Hello,
The **Arun Conservation Area Advisory Panel** wish the following comments to be taken into consideration in the determination of the applications:

AB/136/25/L - Houghton House, 4 Arun Street, Arundel
No Objection

DRAWING
**PROPOSED
ELEVATIONS**

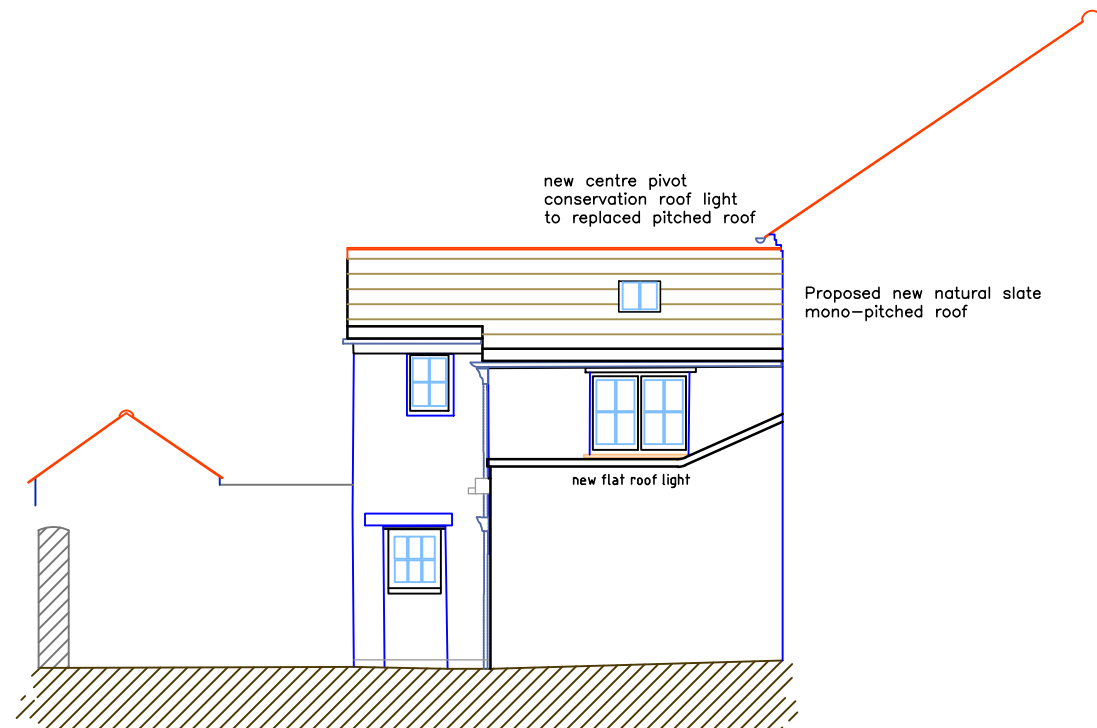
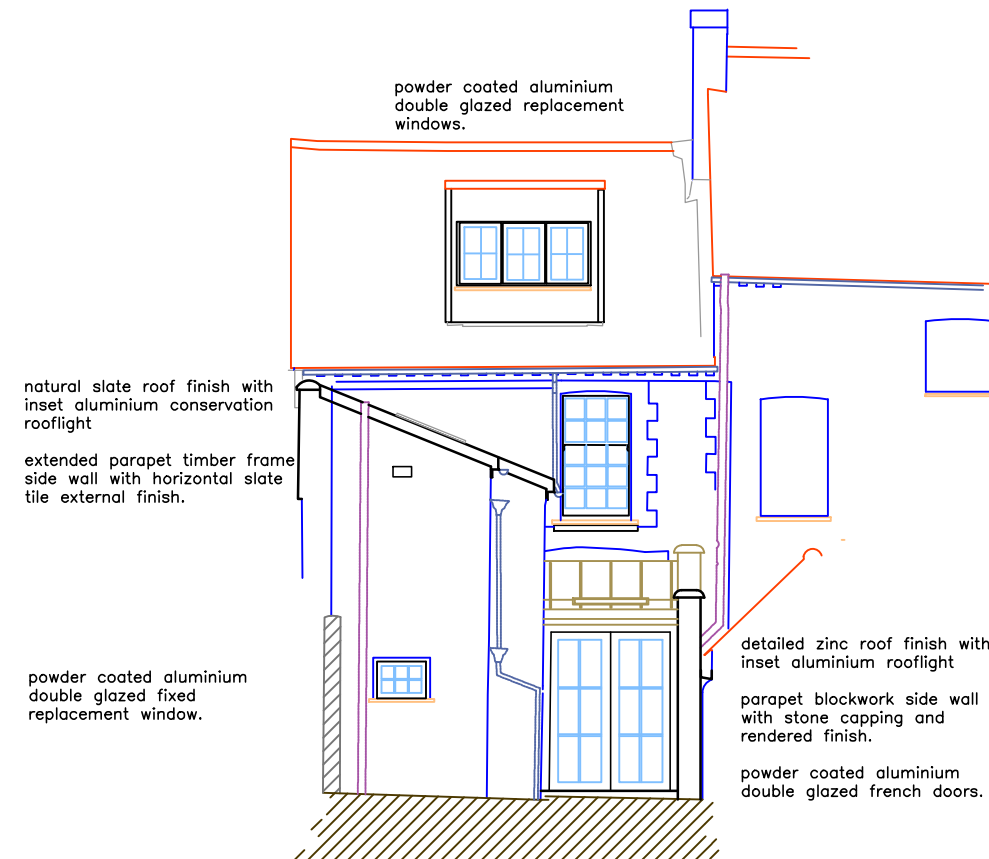
The proposals relate to the rear of the building and, as such, there will be no impact on the character or appearance of the conservation area. The Panel welcomed the overall improvement in the appearance of the fenestration but considered that, given the listed status of the building, painted timber windows, especially the sliding sash one at first floor level on the west elevation, would be more appropriate in this instance than the powder coated aluminium proposed.
Note: Carolyn Kenney declared an interest in the application, left the room, and took no part in the consideration of it.
